New balcony. This application affects the character and appearance of the Arundel Conservation area.

5 The Old Slipway River Road Arundel

DRAWING
Second Floor Plan + Elevations
as Proposed

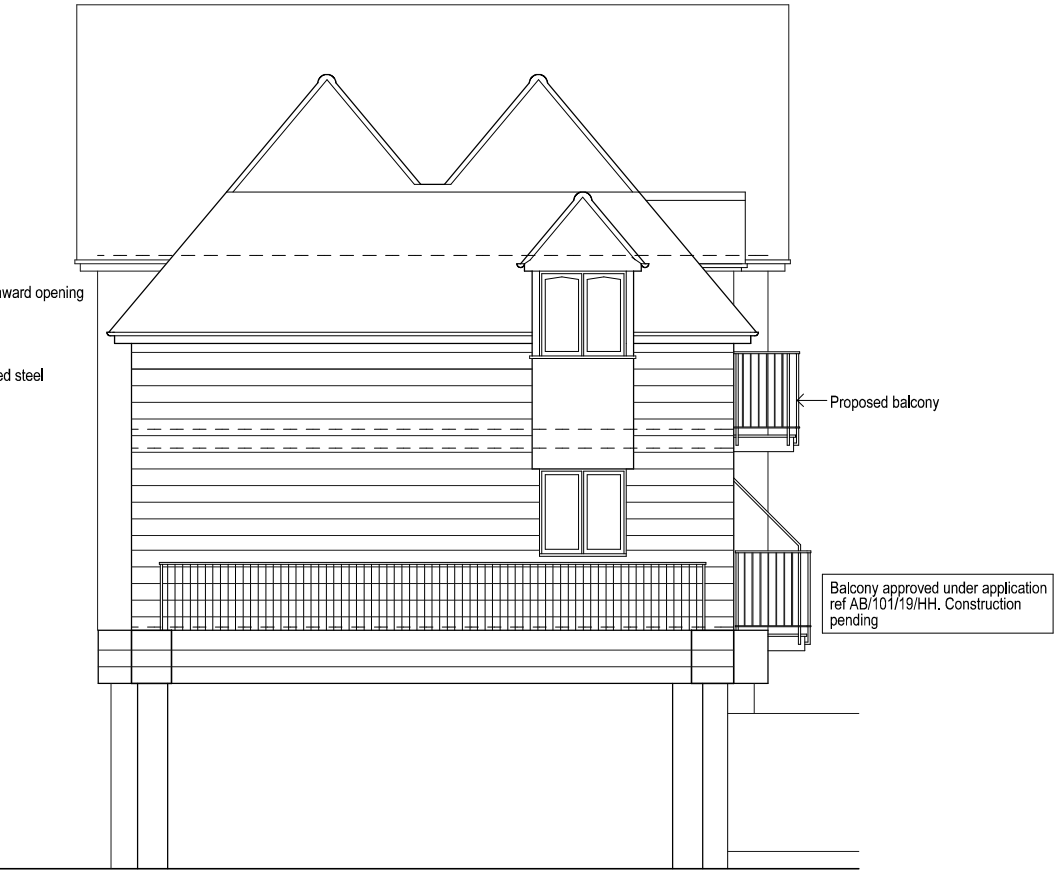
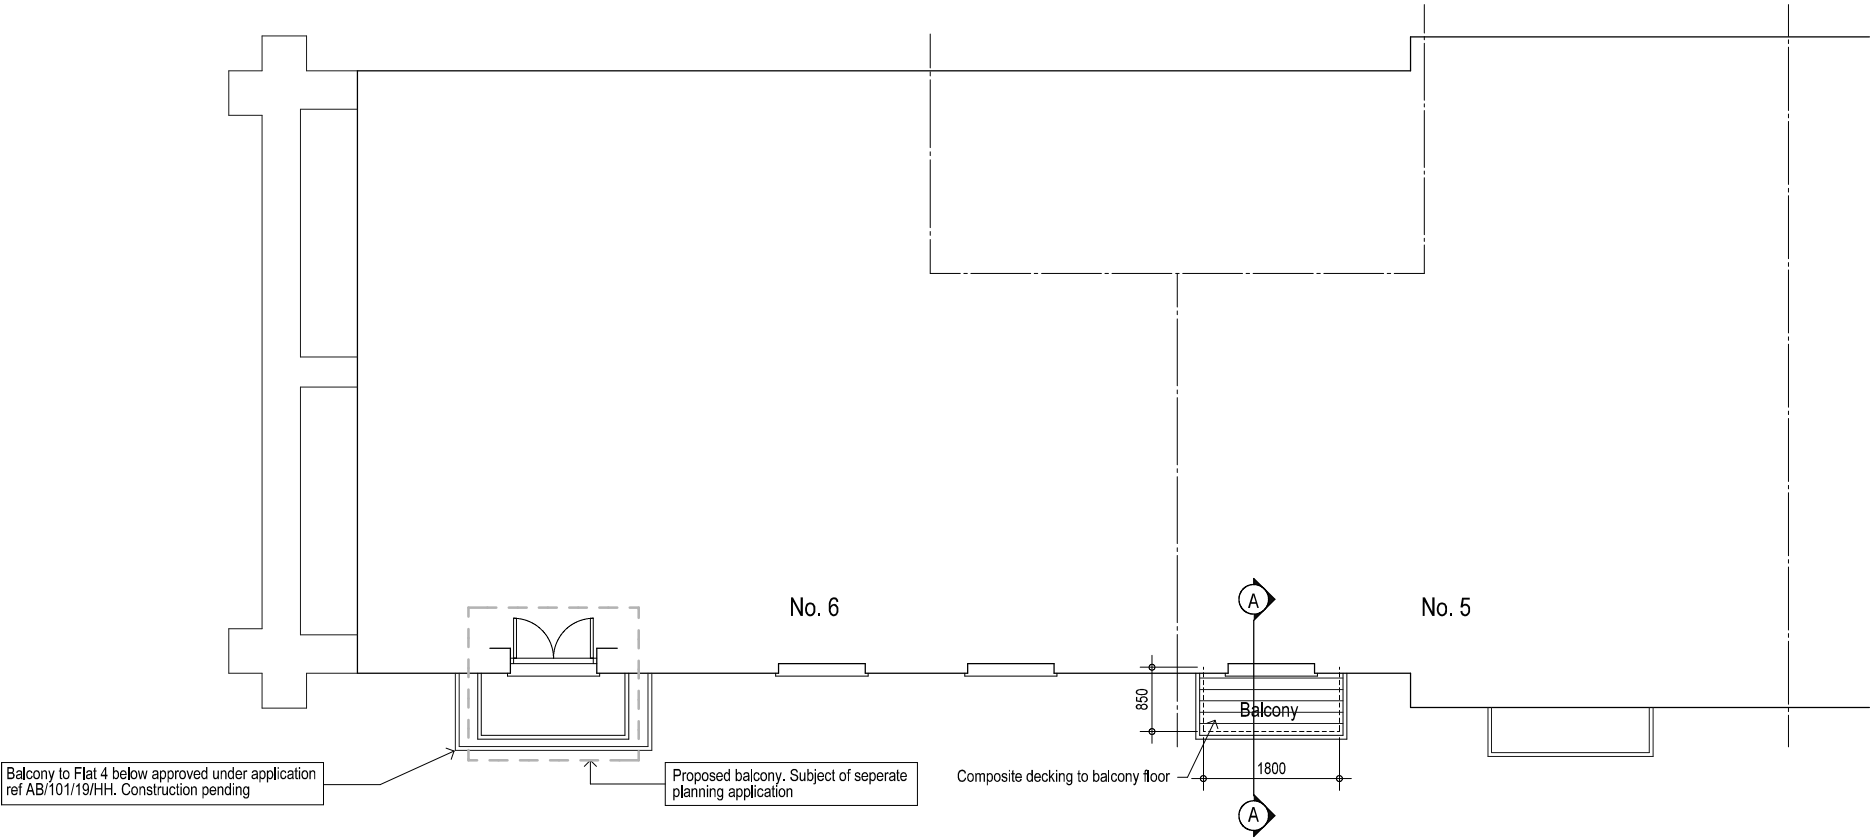
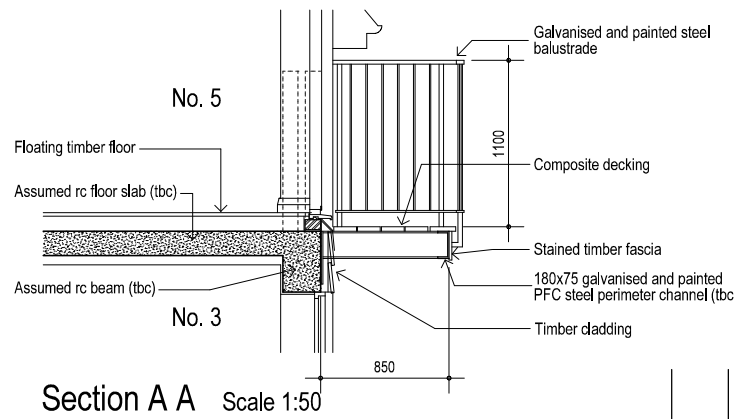
The scale, materials, proportion and size of the proposed balcony is sympathetic with those of the host building. It would be preferable if the proposal were implemented at the same time as the proposed second floor balcony for 6, The Old Slipway, as shown on the plans, because it would maintain the symmetry of the facade. However, given the small scale of the proposed balcony for no5, this is not considered essential.

It is suggested that a condition be attached to any planning permission requiring details of the colour of the paintwork for the balcony since it will be important to ensure a consistent colour scheme for all new balconies on the river elevation of the building.
